## MMC D Street sidewalk construction

I'm attaching a plan for the area of mountable curb along D Street at Alan Prosser's driveway (stamped approved plan set attached as well) . The hope is that this plan, if acceptable to all of you, splits the difference with the neighbor and allows MMC to move forward with the sidewalk construction.

I'm also attaching the CMP related to this work (which you noted would be required when you commented on the overall CMP, Tom). Please take a look and let me know if you have questions or comments. (Mike, I am not sending to Jen, but if she should be included in this review, please feel free to send along.) I will send to fire under separate cover.

VALLEY STREET & "D" STREET INTERSECTION
SCALE: 1"=10'

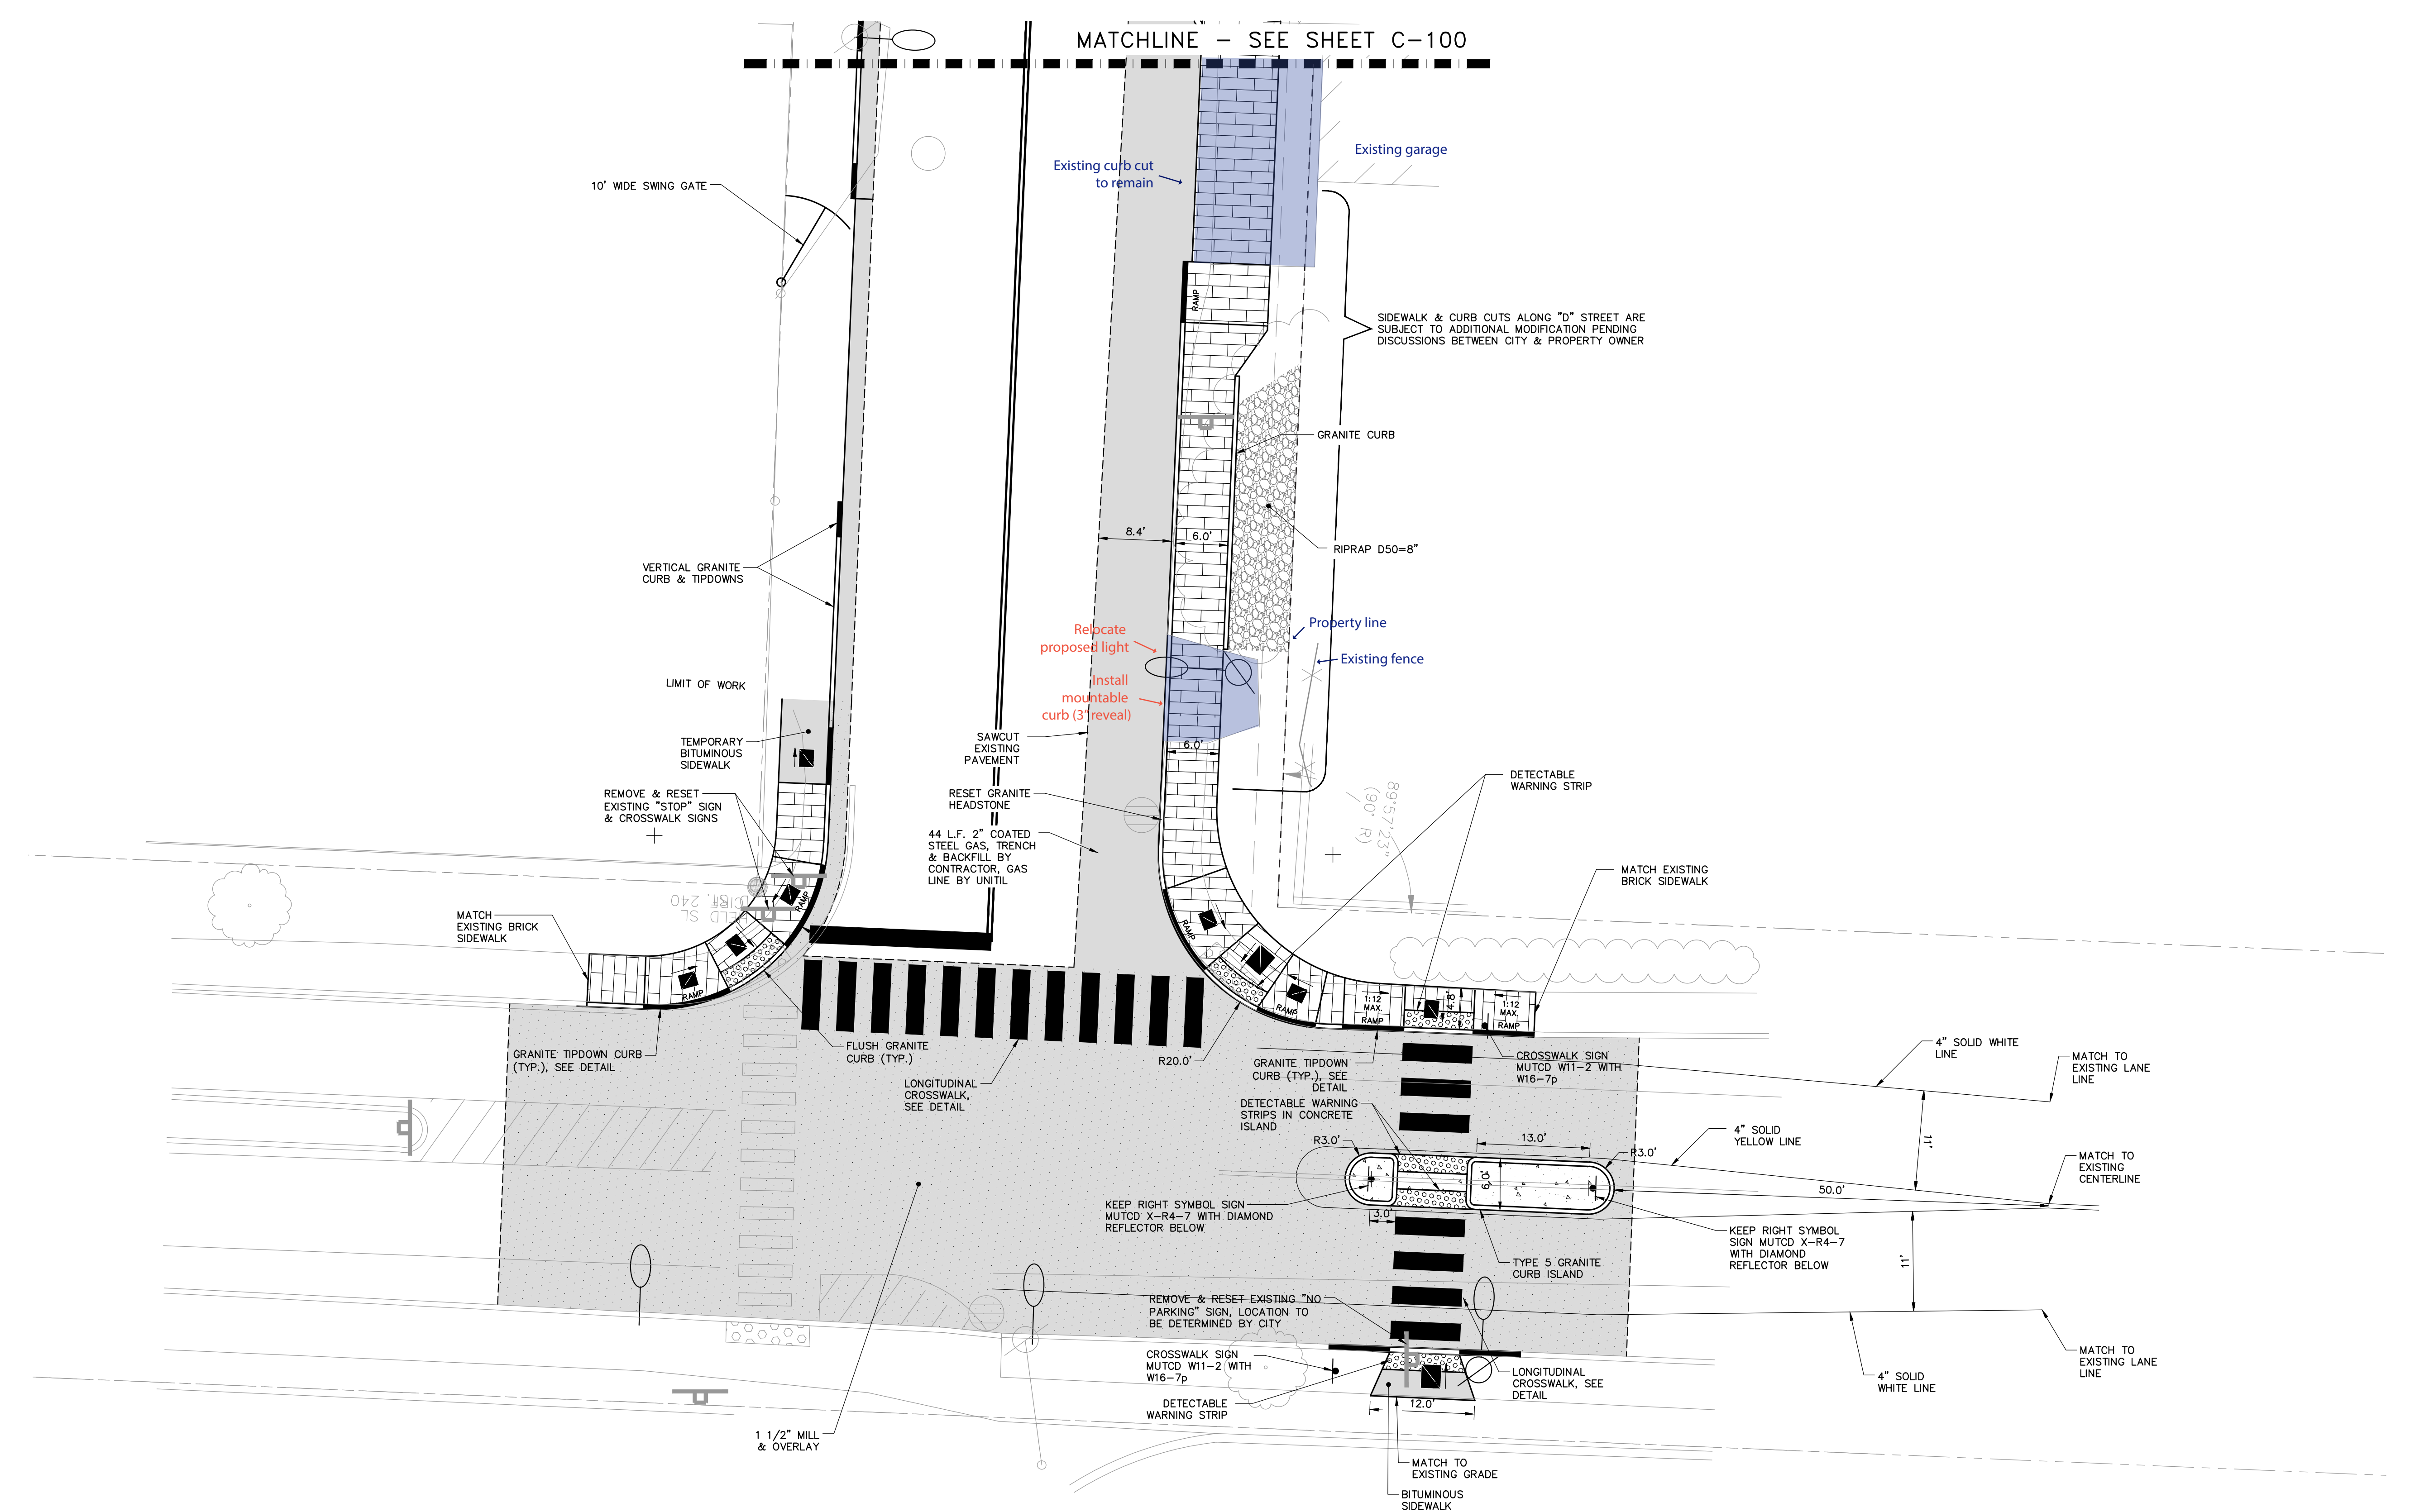
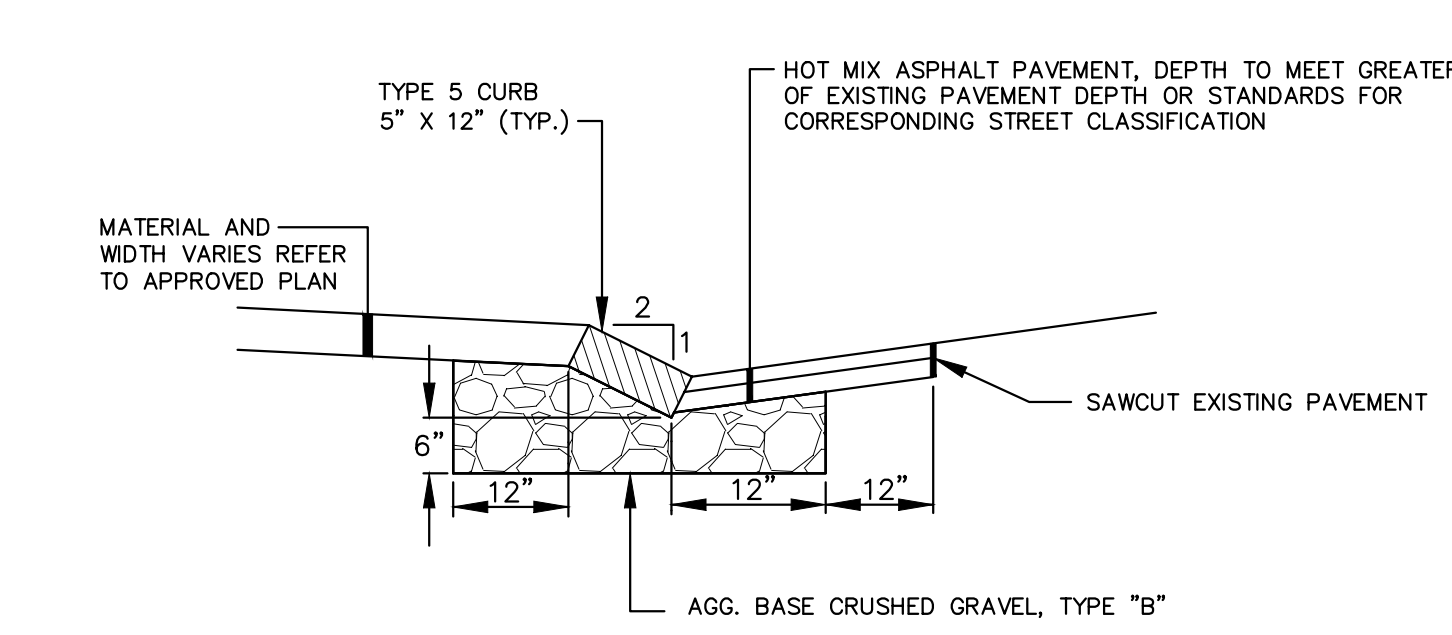
Hi Nell – the only other comment that I would make is that coordination with METRO should take place. I'm not exactly sure of bus stops in this work area. I did not see anything noting METRO impacts. I know it's related to the duration comment, but on-street parking shall be returned when feasible.
